Green Hill Solar Farm

EN010170

Statement of Common Ground: Environment Agency Revision C

Document Reference: EX6/GH8.3.5_C

Drawing file: published-documents / EN010170-001729-GH6.4.4.15_C_ES Figure 4.15_Landscape and Ecology Mitigation Plan E_Sheet 2_Revision C (Tracked).pdf

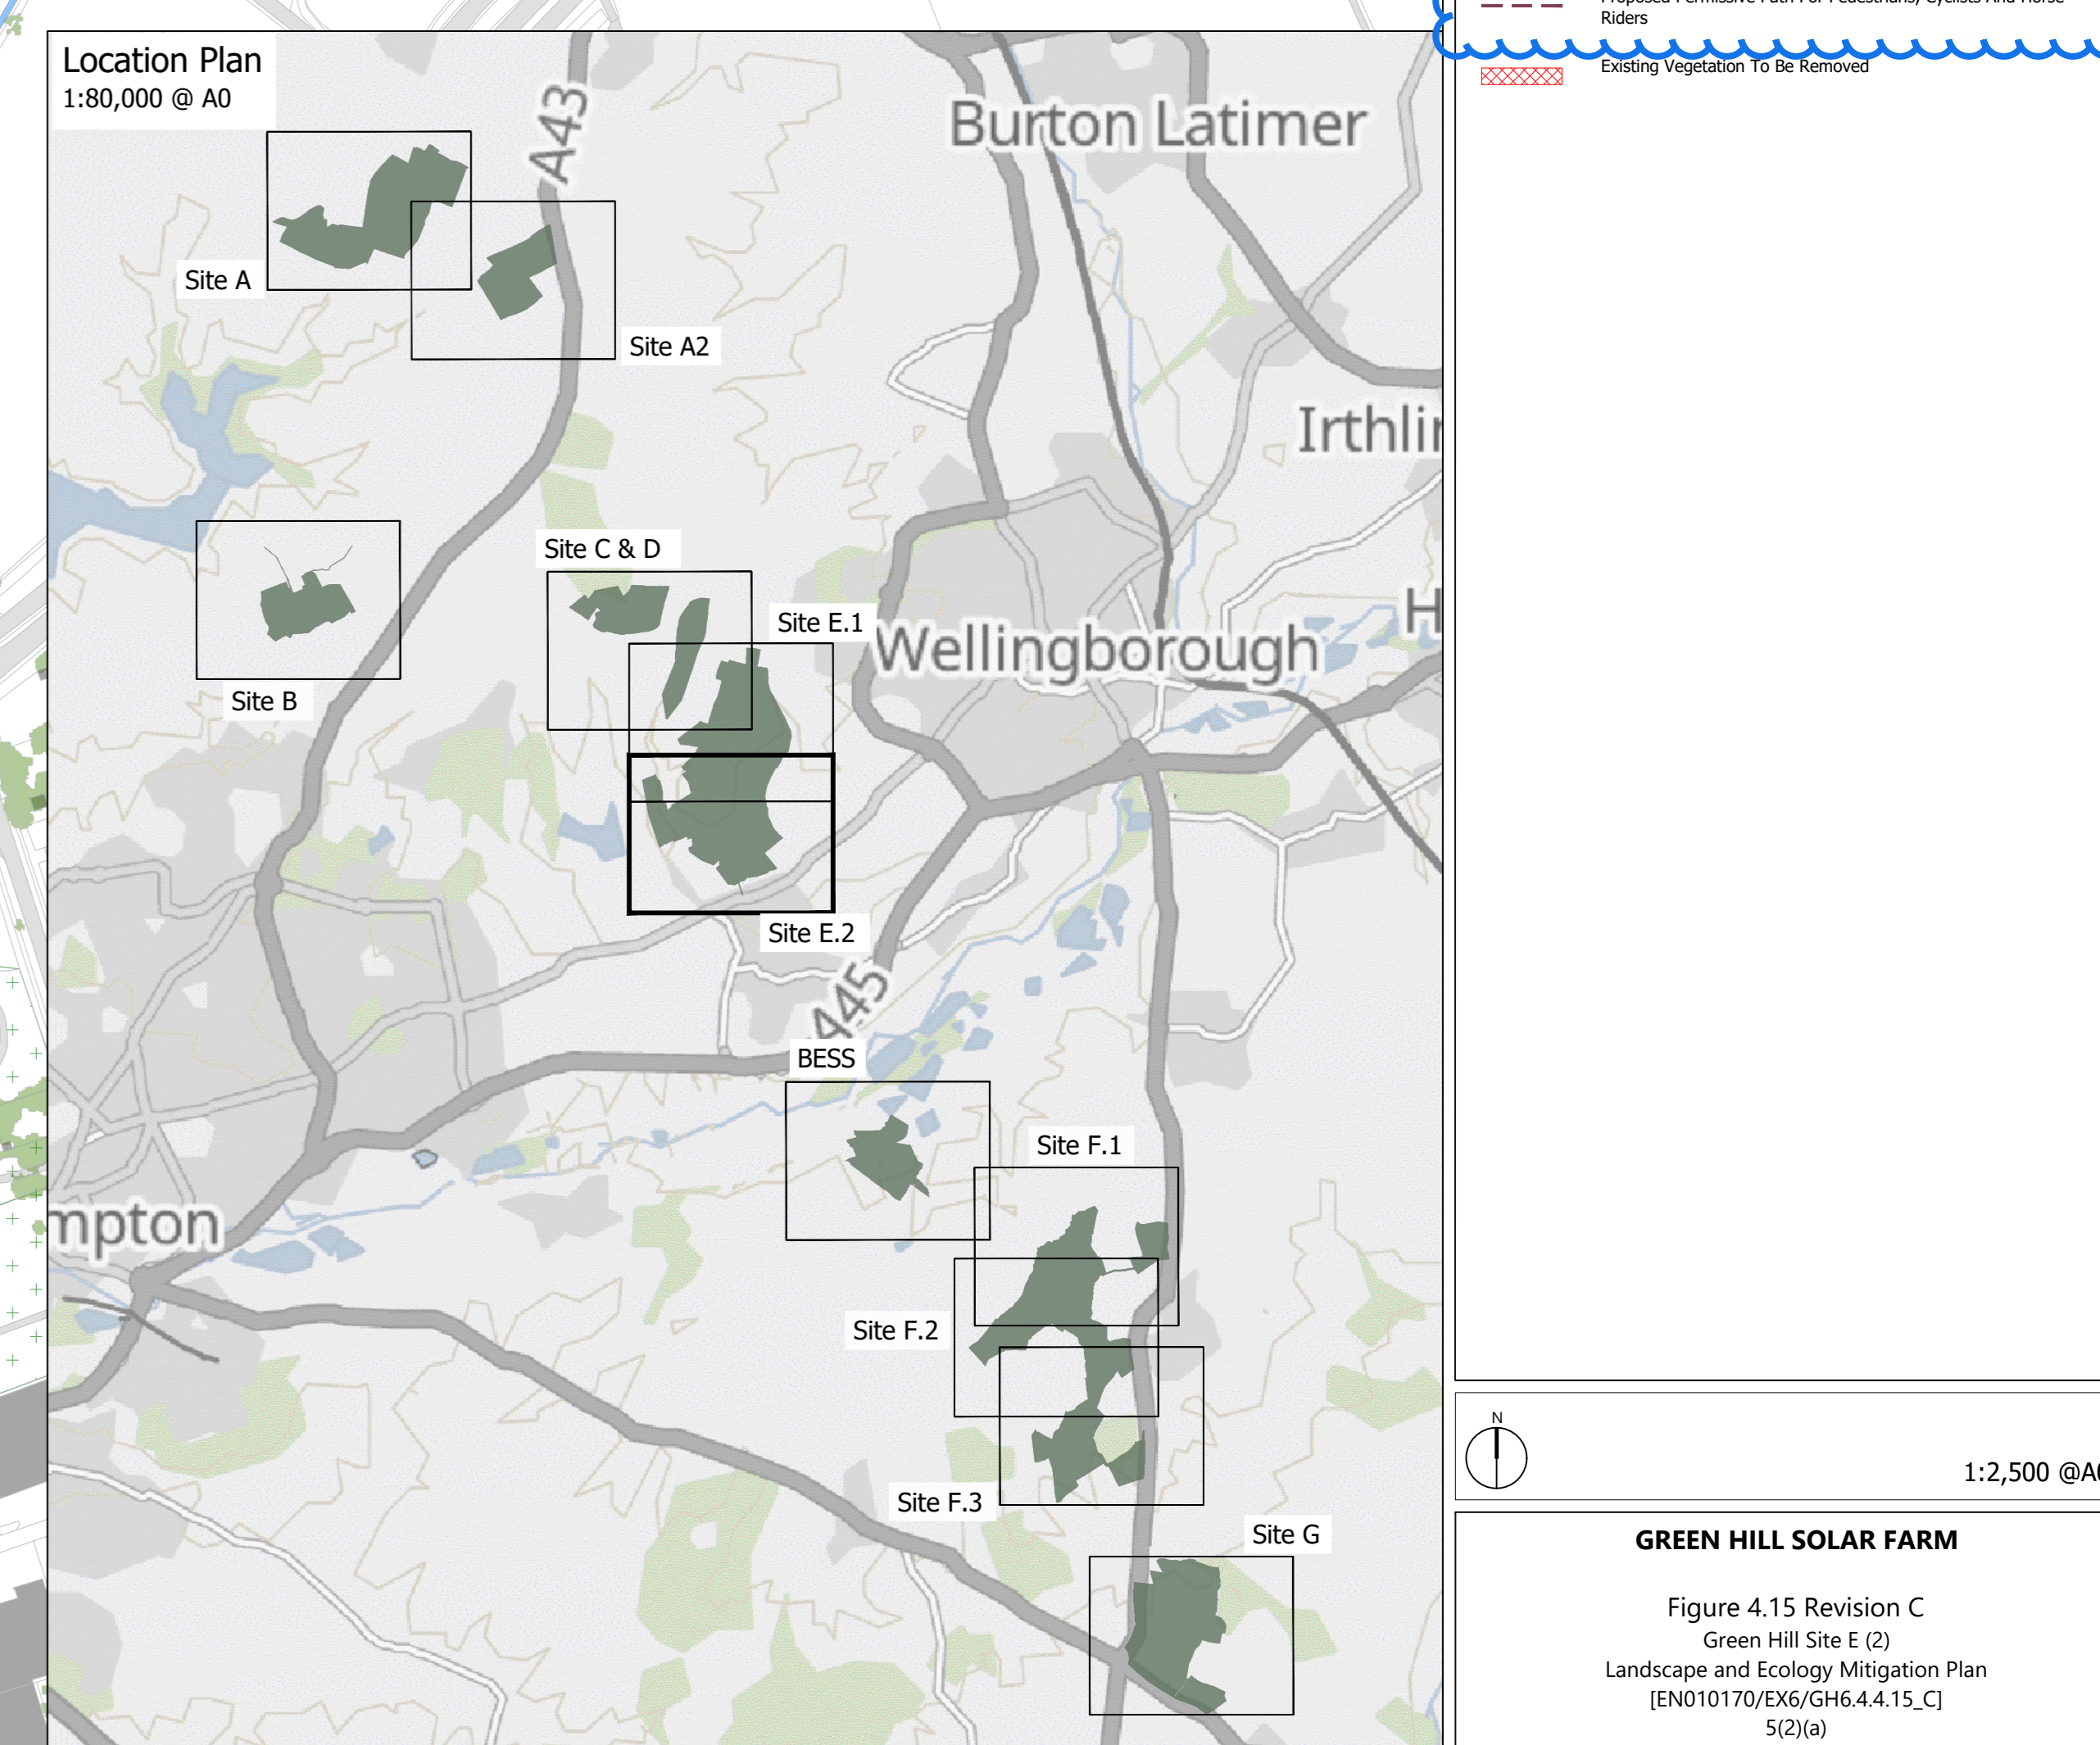
Matter	Details of Matters for Discussion	Applicant Position	Consultee Position	Status
		<p>watercourses are correctly identified, in the proposed MoRPh surveys and BNG assessment as “other rivers and streams”, rather than “ditches”. Minor works to improve these watercourses could result in significant uplift for the project.</p>	<p>Regarding the identification and categorisation of watercourses, please refer to the Applicant’s response to EA-025 in Applicant Responses to Relevant Representations [REP1-161]. Table 9.3 of Environmental Statement Chapter 9 Ecology and Biodiversity (Revision B) [EX6/GH6.2.9_B] gives a summary of the watercourses present on the Sites. Full baseline habitat maps are given in Environmental Statement Appendix 9.2 Habitat Surveys (Revision A) [REP1-045].</p> <p>All watercourses, including ditches, streams and rivers, are protected with undeveloped buffer zones (minimum 8m) through embedded mitigation measures, as per paragraph 9.8.4 of Environmental Statement Chapter 9 Ecology and Biodiversity (Revision B) [EX6/GH6.2.9_B].</p>	<p>concern, and as such is disappointing.</p> <p>To protect natural spring fed watercourses, we would expect some commitment to establishing buffer zones around these features and associated watercourses, e.g. in BNG, minimum riparian buffer for ditch habitat is 5m from banktop. It is possible that this would be sufficient for such watercourses and springheads/wet flushes. Protecting springs and associated headwater channels would also help to prevent deterioration of any WFD waterbodies further downstream.</p> <p>Further information on the importance of headwaters can be found via this link: CaBA-Biodiversity-Pack-Headwaters.pdf</p> <p>We note the commitment to buffers, we require clarity on protection of headwaters/wet flushes/springheads -</p>

Matter	Details of Matters for Discussion	Applicant Position	Consultee Position	Status
			<p>Applicant Response to Consultee Position</p> <p>“Wet flushes” is not a defined hydrological or regulatory category. There is no recognised spatial dataset for wet flushes and they do not constitute a separate waterbody type requiring standalone assessment.</p> <p>In respect of headwaters, these are the upstream extents of the same watercourses already identified and assessed within ES Chapter 10. The assessment considers watercourses as whole systems. Embedded mitigation applies to all watercourses irrespective of size or stream order, including buffers, avoidance of in-channel works except agreed crossings, and standard pollution prevention measures. The upper reaches are therefore already captured within the overall assessment and protection framework.</p>	<p>springs/wet flushes are not ditches/other watercourses streams, could even be classified as an area habitat unit under BNG, rather than a linear (watercourse) unit, so could come under the 20m buffer for ponds/moderate watercourses.</p> <p>Consultee Position following Applicant Response 17/03/2026</p> <p>We have identified at least one spring within the Order limits of Area E, just north of Brook Hill Farm and one very close to the southern boundary.</p> <p>For the avoidance of doubt - “Springs and flushes are areas where water from underground – called groundwater – flows out onto the surface to create freshwater and wetland habitats.</p> <p>Springs are the locations where water bubbles out of the ground, which can then either flow into obvious stream channels or spread across the ground to</p>

Matter	Details of Matters for Discussion	Applicant Position	Consultee Position	Status
			<p>Applicant Response to Consultee Position 24/03/2026</p> <p>Green Hill EF29 and EF30 do not include panels and are proposed areas of diverse wildflower meadow as shown on ES Figure 4.15 Landscape and Ecology Mitigation Plan E (Sheet 2) [EX6/GH6.4.4.15_C].</p> <p>Panels within Green Hill EF27 been offset from Hockerhill Farm. Based on a review of approximate markup provided by the Environment Agency and Ordnance Survey data, the panels appear to be appropriately offset from the identified spring.</p> <p>If springs were present and contributing to a wet habitat (such as a watercourse or wet grassland), these habitats would have been recorded as such during the habitat walkover surveys. These surveys were completed at various times of year between August 2023 and September 2025 across the Order Limits, and plant communities associated with wet</p>	<p>make an area of wetland that doesn't have a single channel.</p> <p>Flushes are essentially a special kind of springline wetland, where the water is flowing diffusely across the ground surface, held up by impermeable soils and rock." – Freshwater Habitats Trust [accessed 16/03/26]</p> <p>It is pleasing to see that the headwaters of the watercourses identified in Chapter 10 of the ES will be subject to the suggested buffers included in the protection framework.</p>
